Our Ref: Y/42/19/DOC

Approval of details reserved by condition imposed under ref Y/53/16/PL relating to Condition Nos 3 - surface water drainage, 4 - maintenance & management of SuDs system, 5 - site set up and 7 - protective fencing/site monitoring.

Yapton Metal Company Burndell Road Yapton BN18 0HP

Arun District Council have decided to **REFUSE details reserved by condition for the following reasons:**

Drawing Reference : J20438_Arb_TPP_A

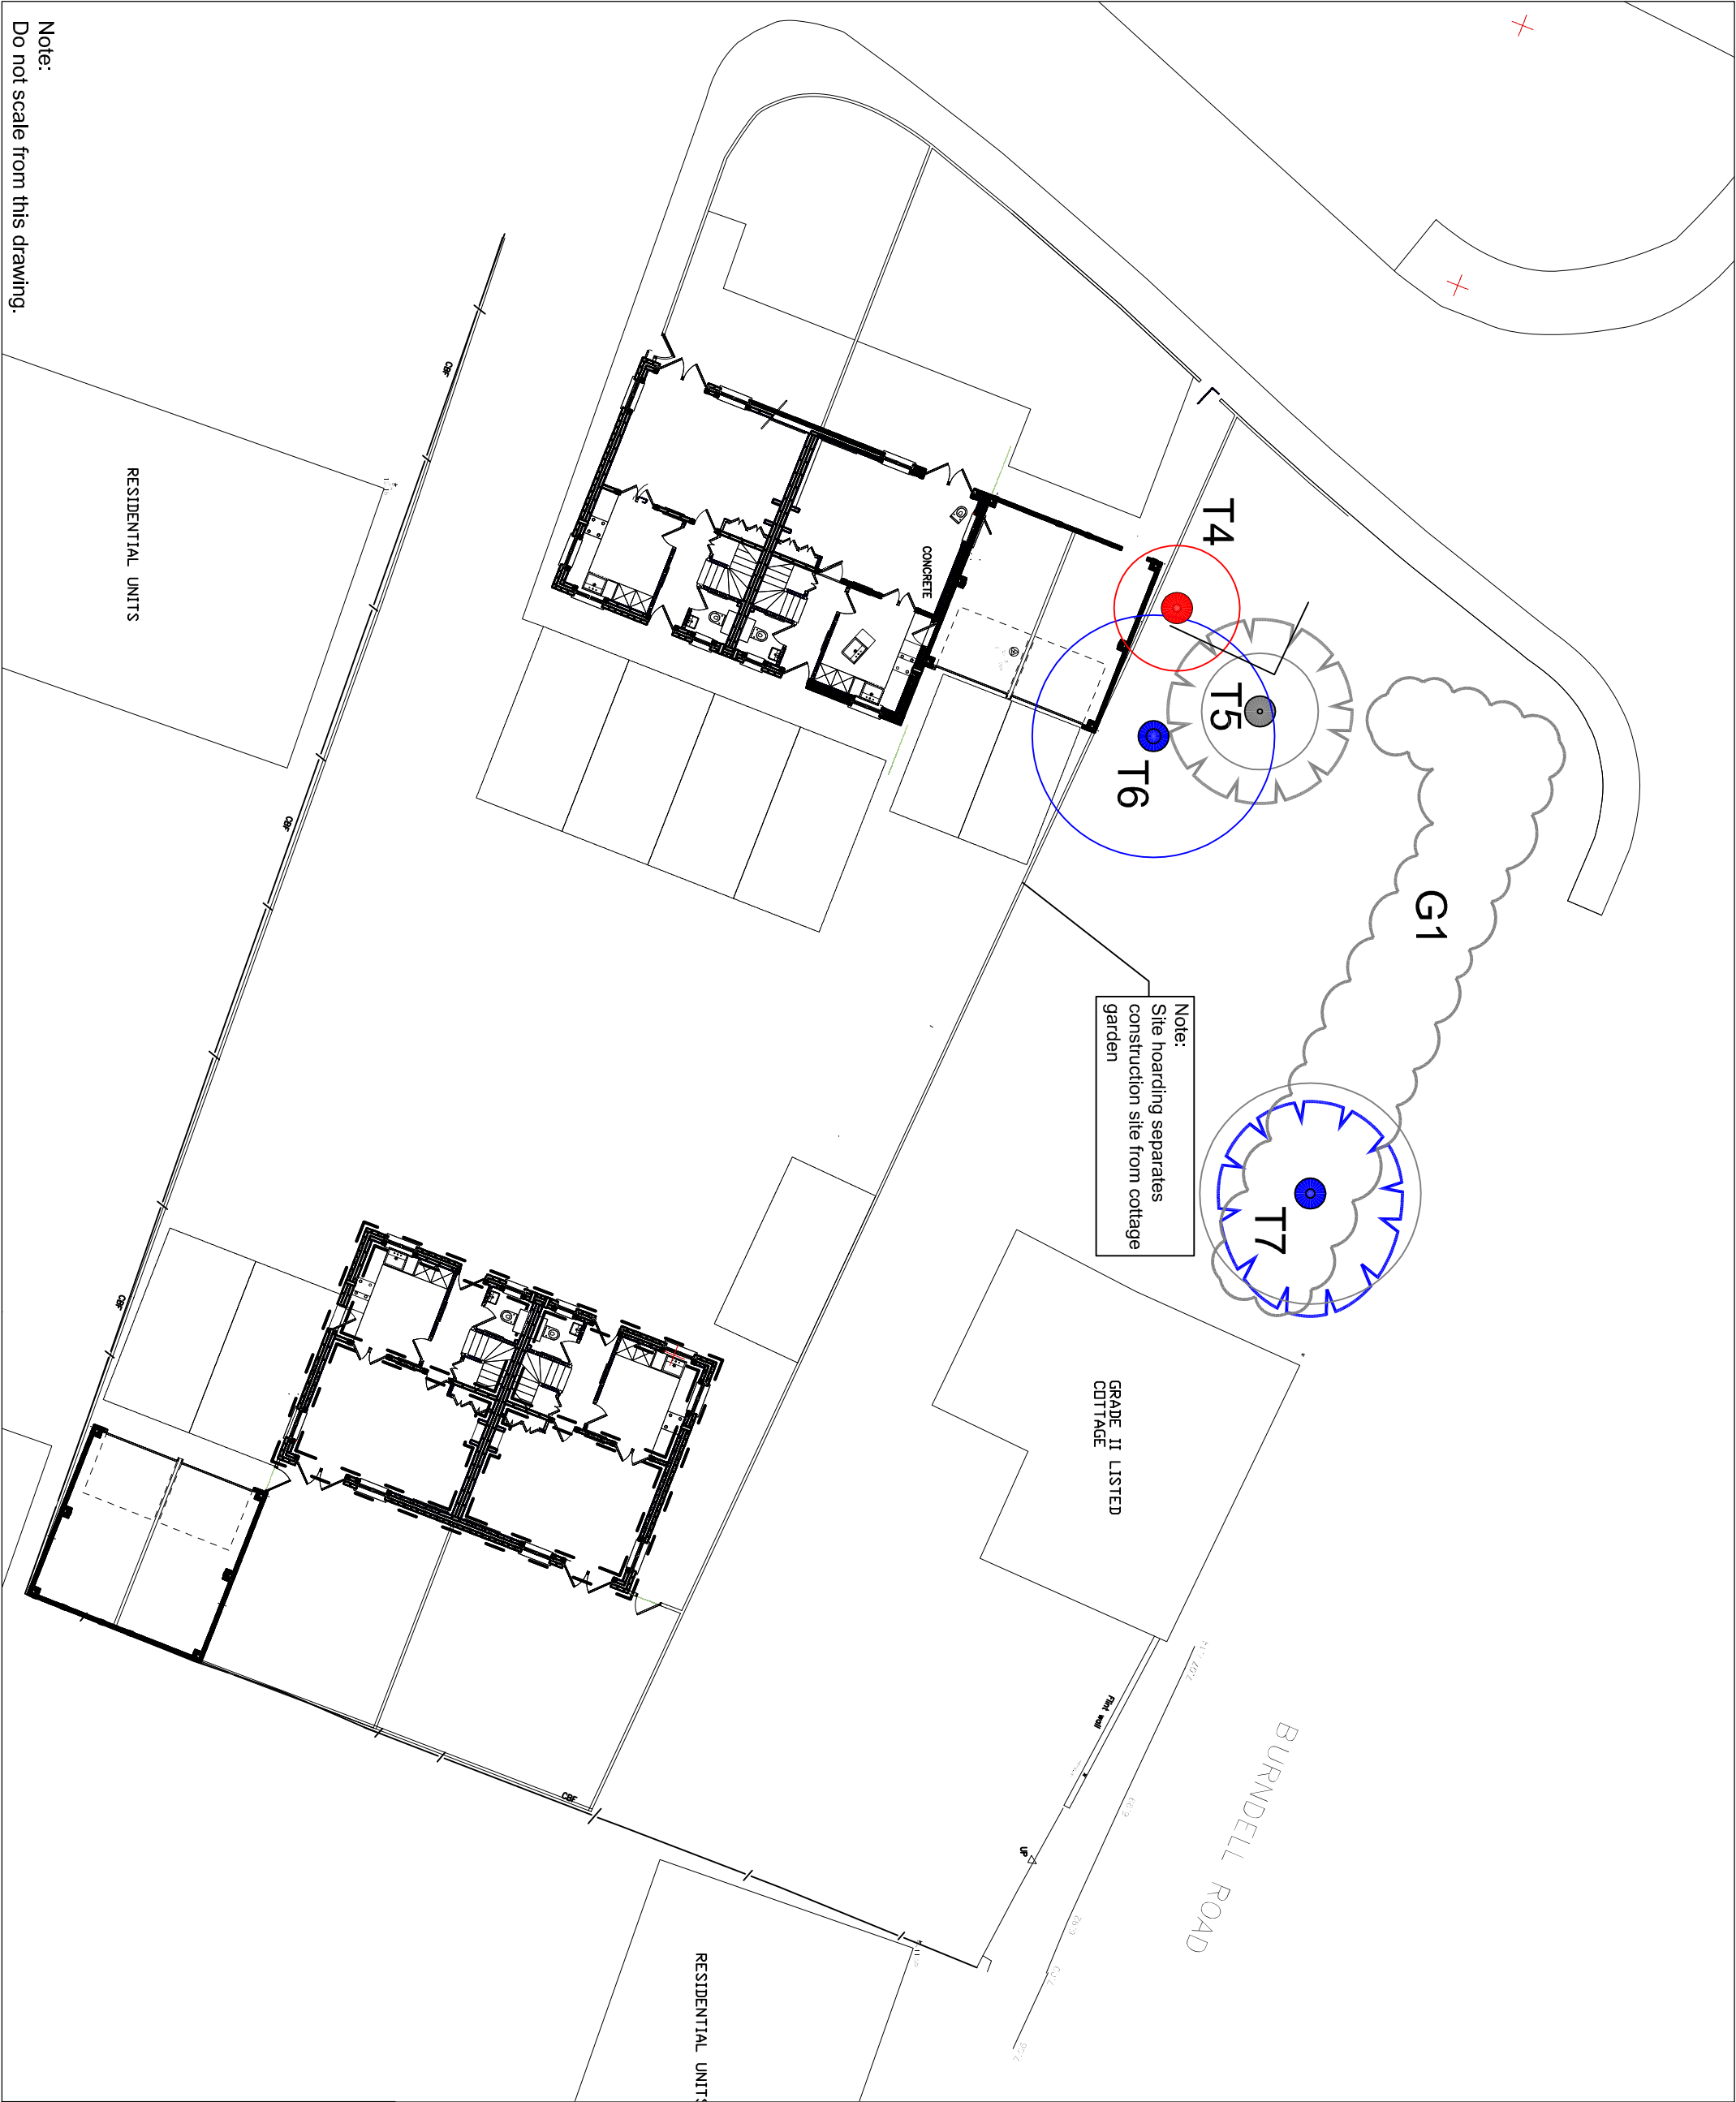
* A pre-commencement site meeting is to take place between the Arun DC Tree Officer and the Arboricultural Consultant representing the site owners - at this meeting all protective fencing will be inspected along with ground protection measures - they will be assessed to verify that they are 'Fit for Purpose' as required under British Standard 5837:2012 and have been erected and positioned exactly as shown on the Tree Protection Plan J20438_Arb_TPP-06.07.17.

This condition required that no development commence unless/until a the proposed tree and ground protection measures have been agreed and that a schedule of Site Monitoring/Supervision visits is also to be agreed to allow monitoring of the development.

The development commenced without the approval of these details and has since been largely completed.

Our tree officer has visited the site and is not confident from the information submitted that the trees to be retained were adequately protected during the construction process.

On this basis, it is not possible to discharge the condition and I would recommend that prior to making any further application, you first obtain informal agreement to the discharge from our tree officer. Alternatively, you could apply to remove the condition entirely.
